Bryceson Shaw Associates

13/01/2018

Our ref.: 2176

44 Tarrant Street, Arundel

Job Title	44 Tarrant Street, Arundel		
Client	Mr & Mrs N Field		
Drawing Name	Plans, Lower and Ground Floors		
Drawing Status	Planning & Building Regulations		
Drawn by	AF	Date	11/17
Checked by		Date	
Drawing Scale	1:50 at A1 1:100 at A3		
Drawing No	Status	Revision	
171164/ 103		B

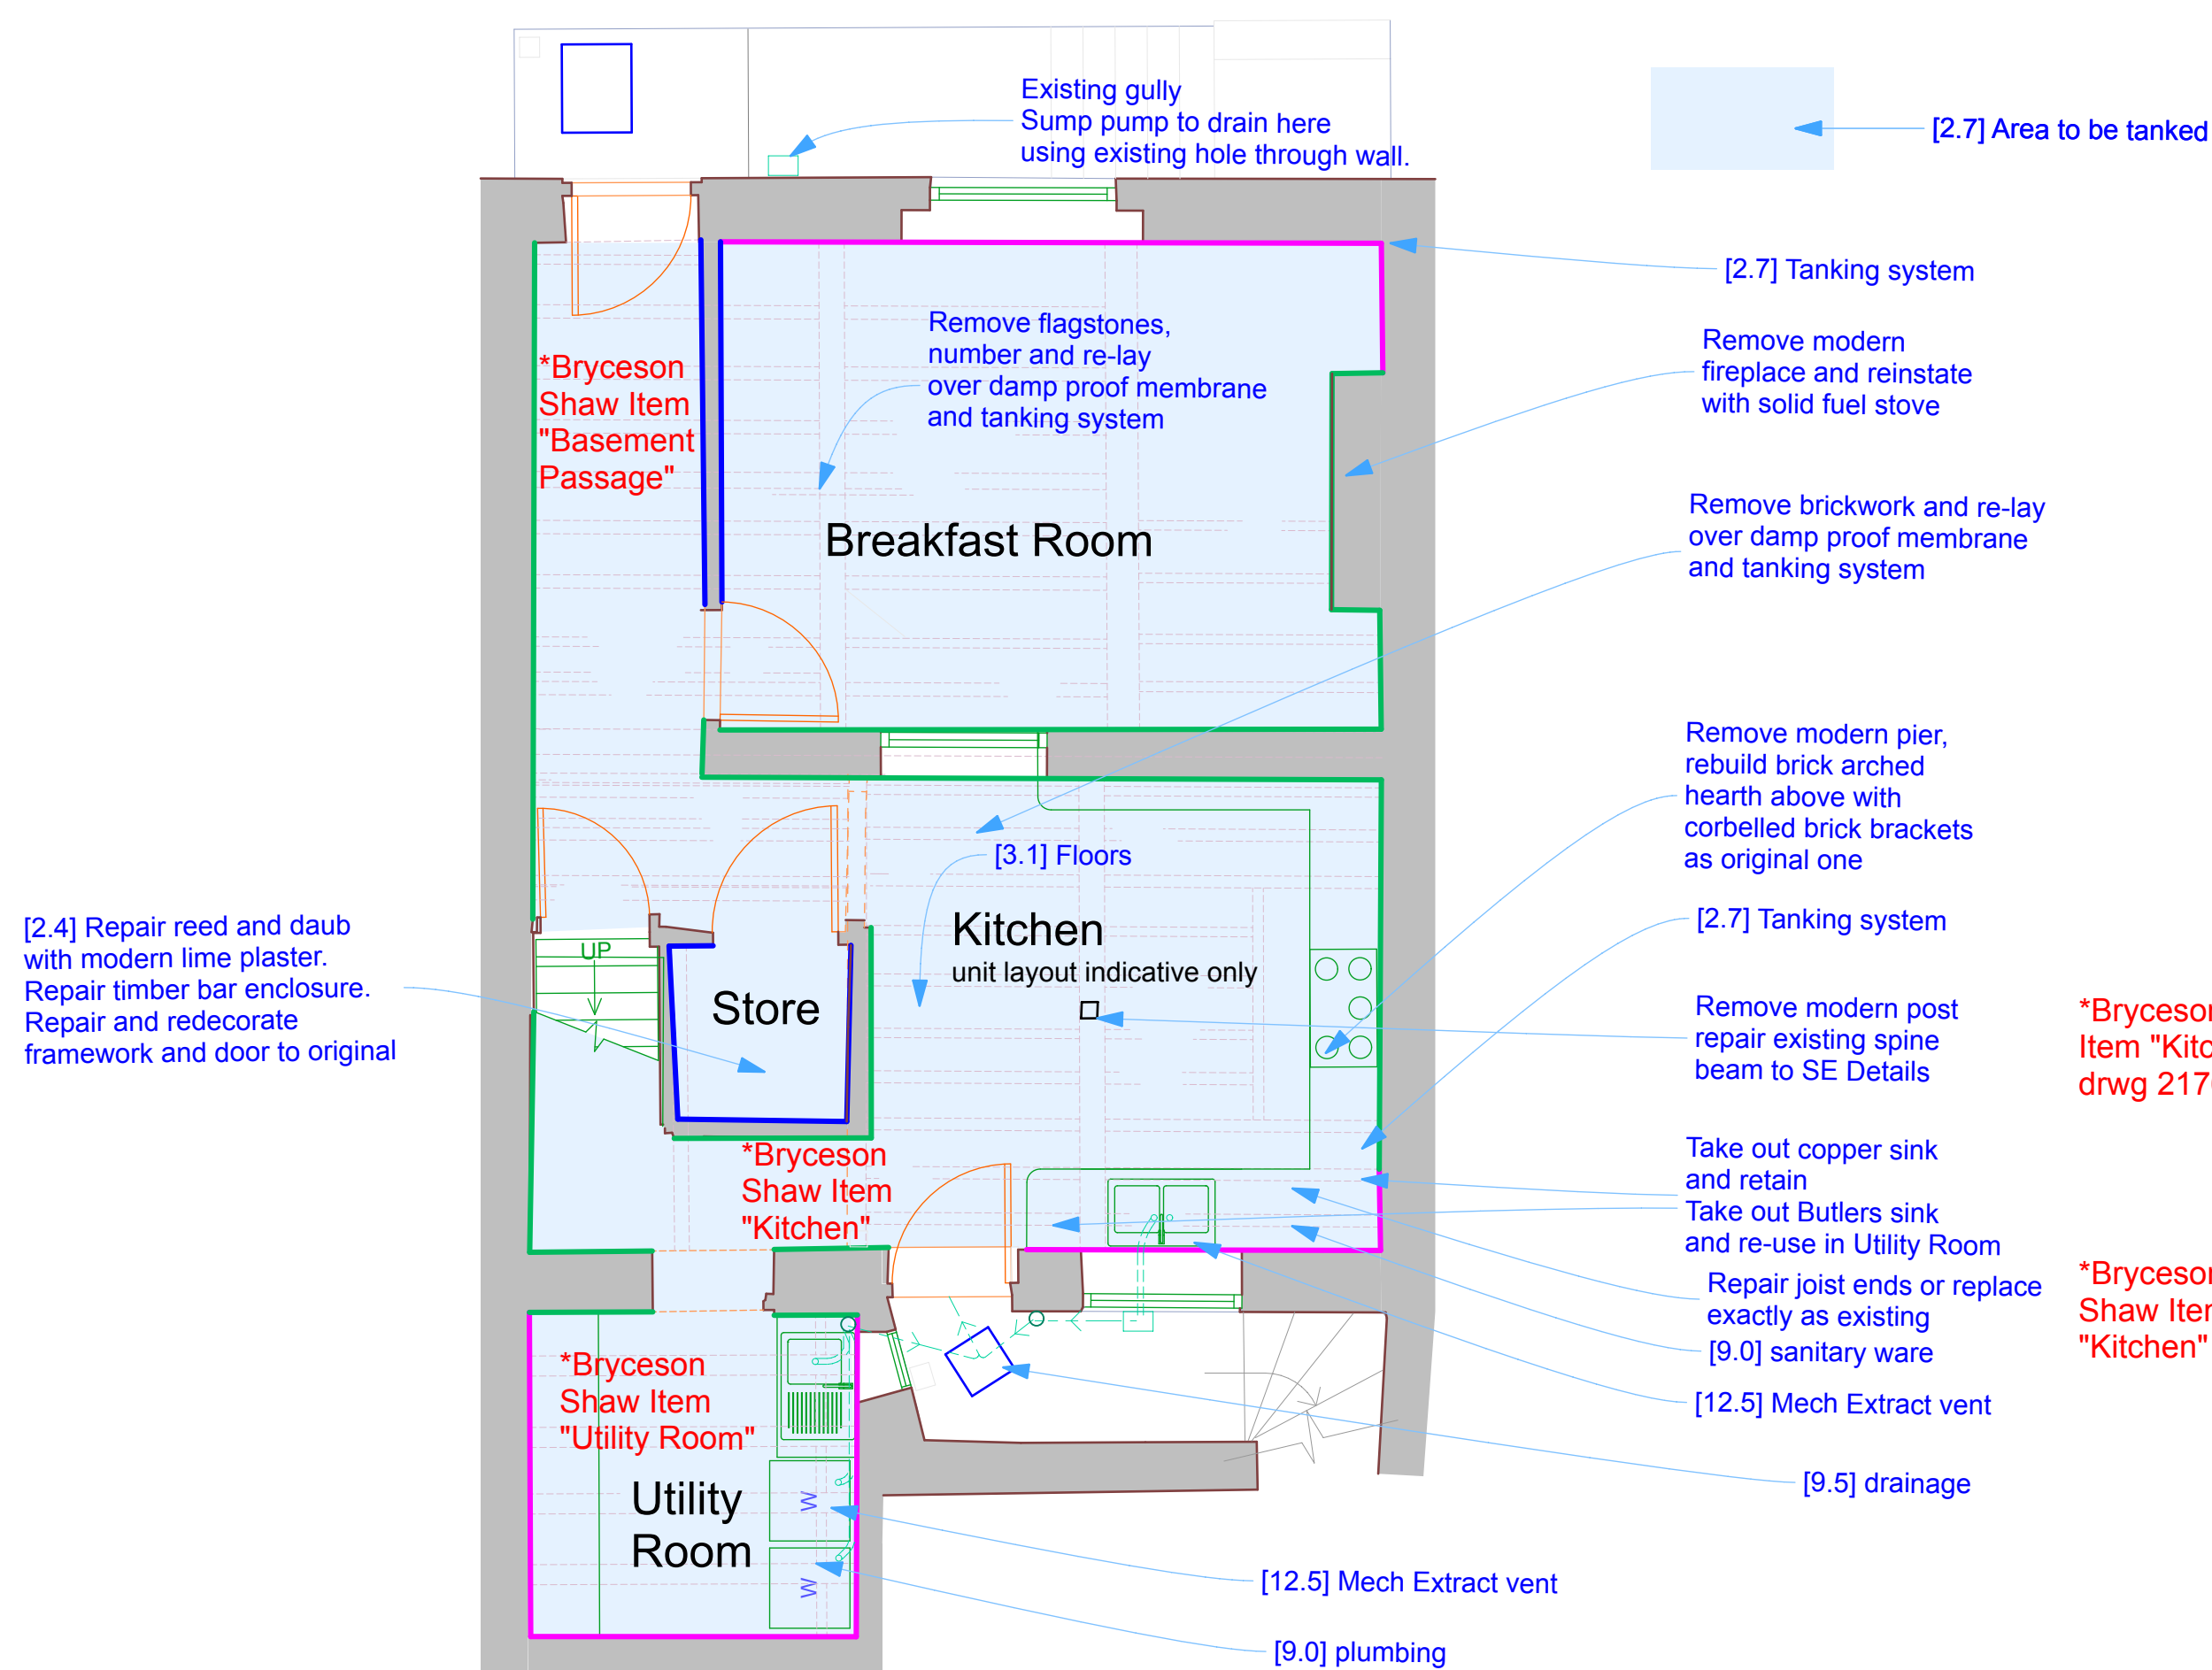
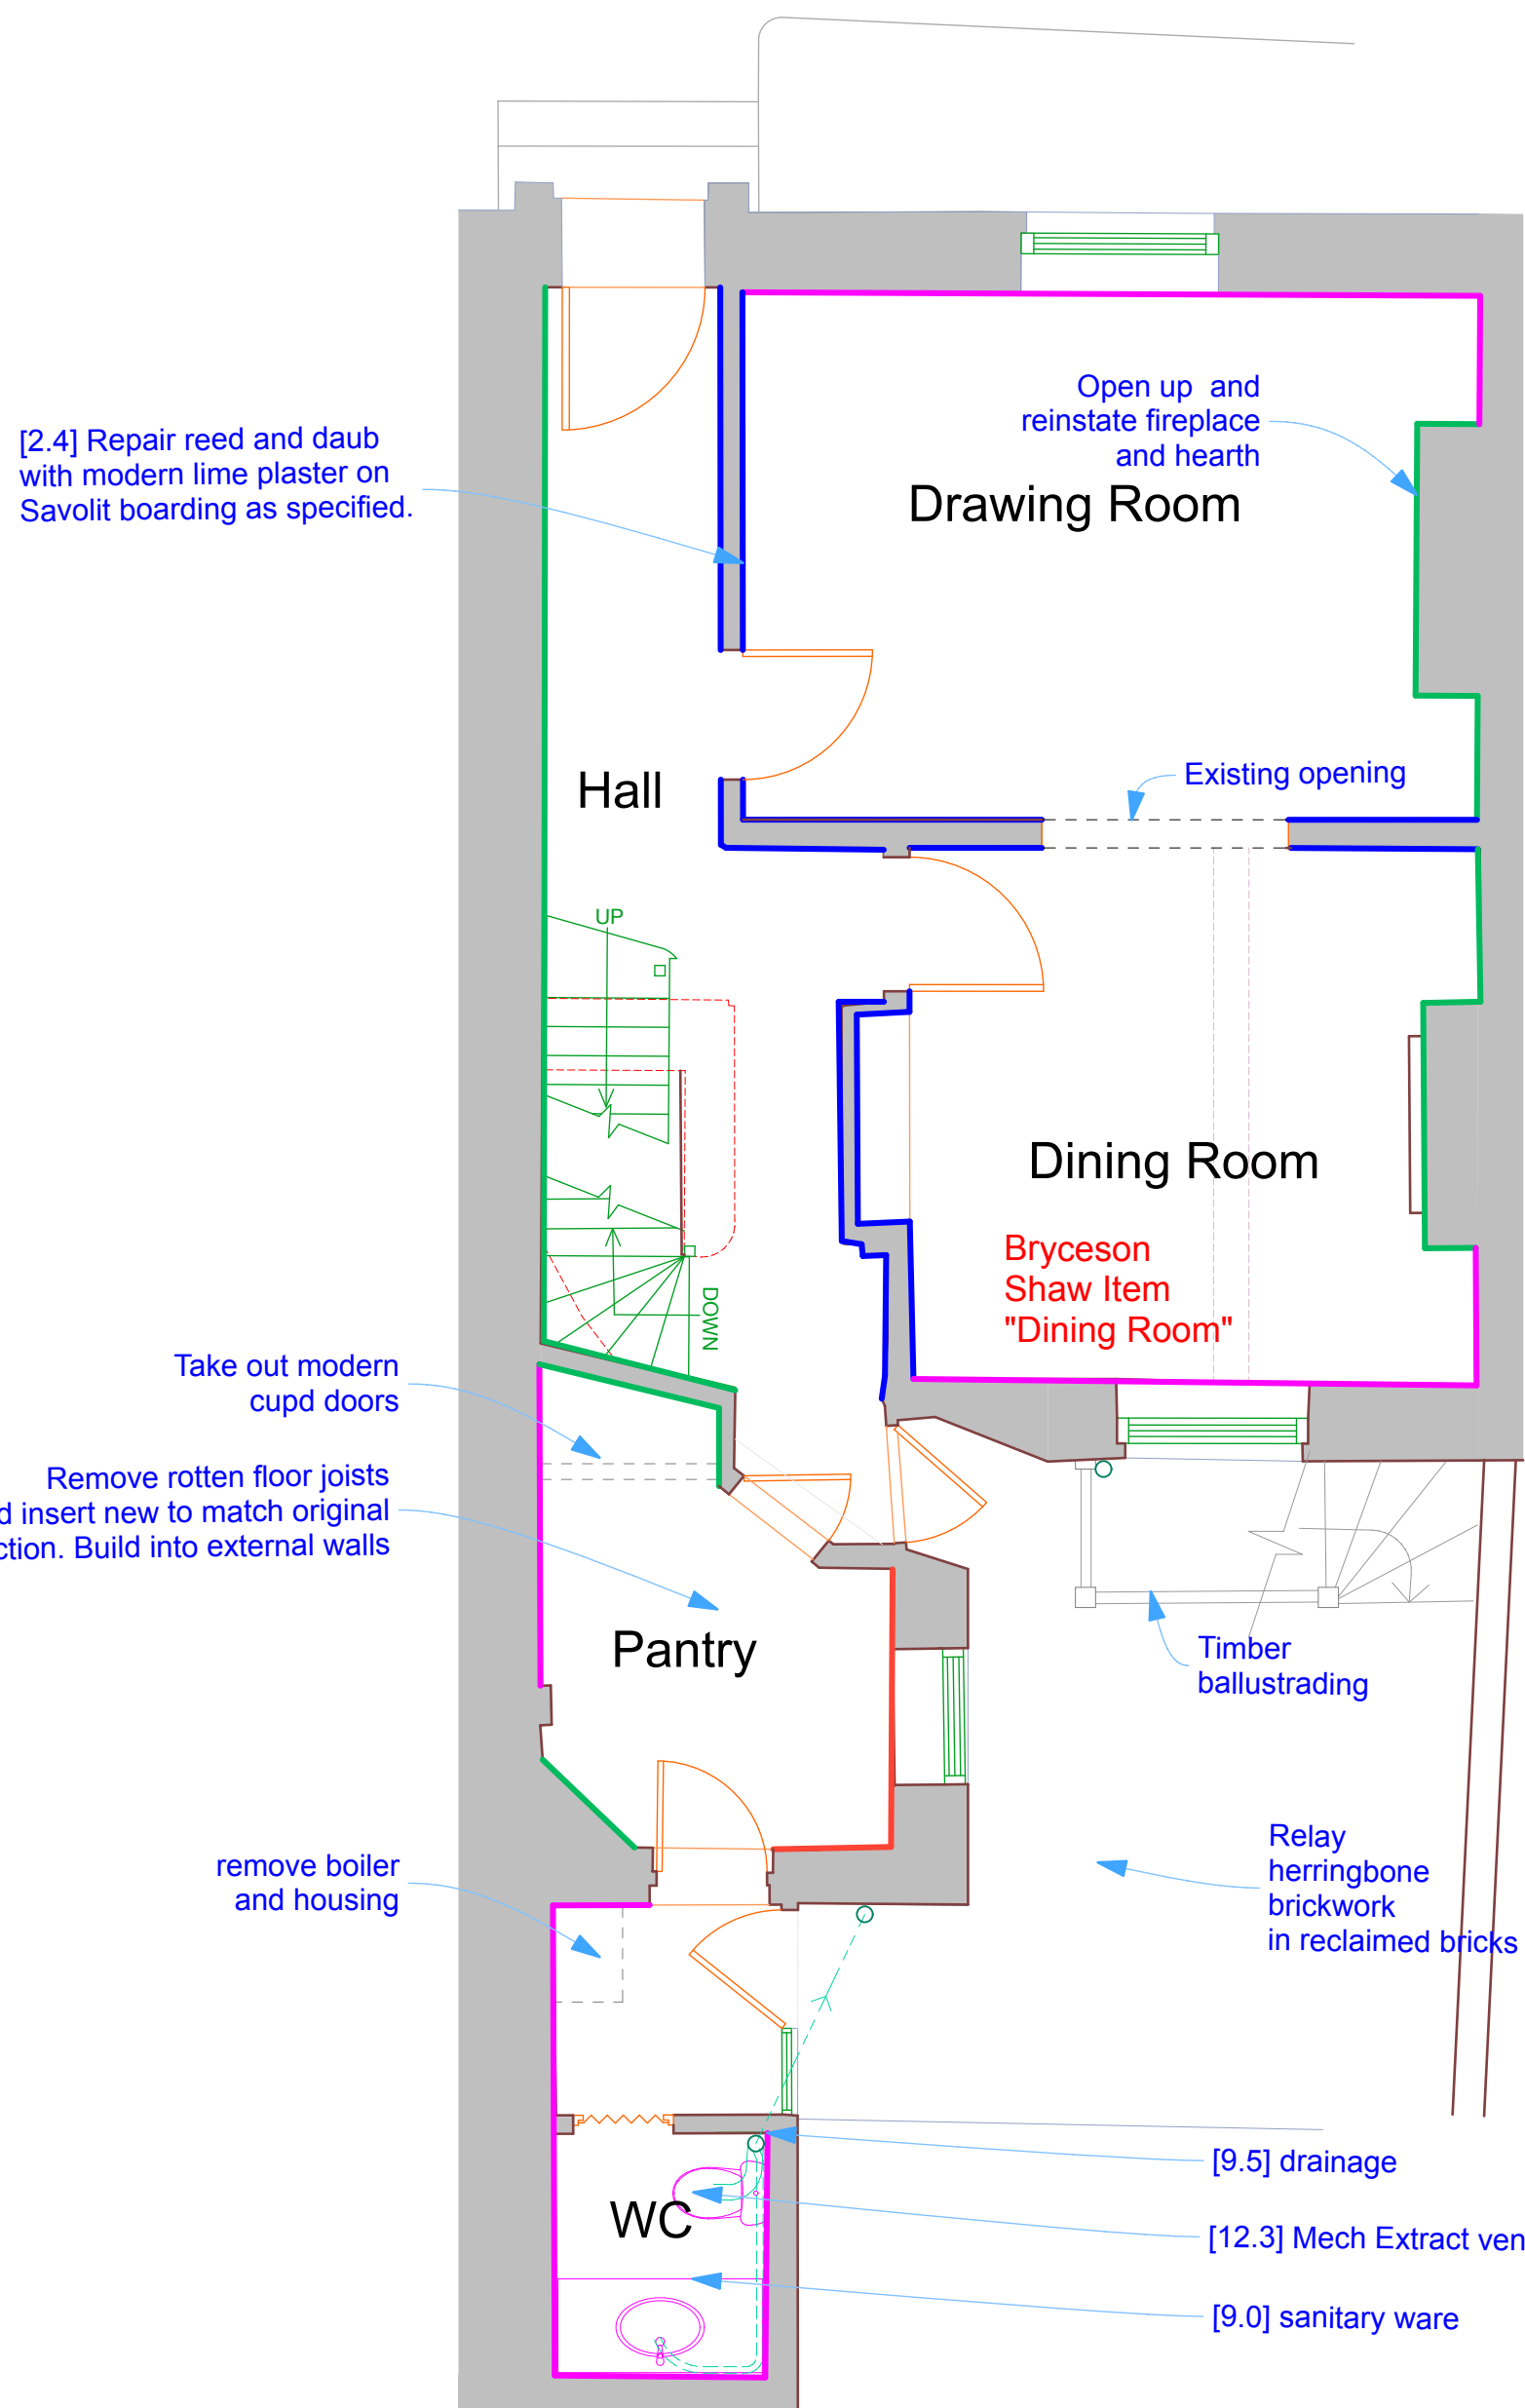
The joists in the Northwest corner had rotted away at the ends in the party wall and been supported by an inappropriate structure that obscured original structure. Upon removal of the joists to consider repair to the ends it was found that the timber had decayed/rotted to the point where repair was not going to result in structurally sound timber. The 3 joists had to be replaced with new oak of the same section.

The summer beam supporting the joists is propped with a central post and it was desired to remove this. The beam has a major split along its length and this explains the post. A drawing was prepared detailing in-situ reinforcing repairs to the beam. The outer end of the beam was supported with a section of timber post that obscured the window because the lintel had decayed. As the wall was to be re-plastered a discrete section of steel box section was inserted as the new lintel.

The beam over the doorway to the utility room has rotted away where it was built into the rear wall and is supported with a post. I do not believe the beam can be removed so an in-situ repair to the end will have to be done. The end of the beam will have to be cut back and some other structure removed to allow access, a section of species and moisture content matched timber can then be attached to the end using the Rotafix system as detailed on a drawing.

There was a rotting false floor over this room and the original joists under were also badly rotted and decayed to the point where it was not considered safe for operatives to work on the floor. Upon stripping the structure it was apparent that the joists could not be rendered structurally sound with any means of repair so for safety they had to be replaced with oak of the same section.

The partition between this room and the cupboard in the landing is loose where decay has occurred. It is proposed to lift the floor boards above the area and insert a section of timber into the top of the partition that can then be secured to adjoining floor joists.

Some of the joists over the Southern end of the passage have been sistered with modern timber because of rot where they were built into the party wall. Other joists in the same area are in a similar condition but would be difficult to remove because of the partition with the front room so it is proposed to sister them alongside as well.

The Southern end of the partition with the front room has lost a section of its sole plate because of rot. As access is available on the room side the damaged plate can be cut back to sound timber and a new section sole plate inserted to pick up the studs.
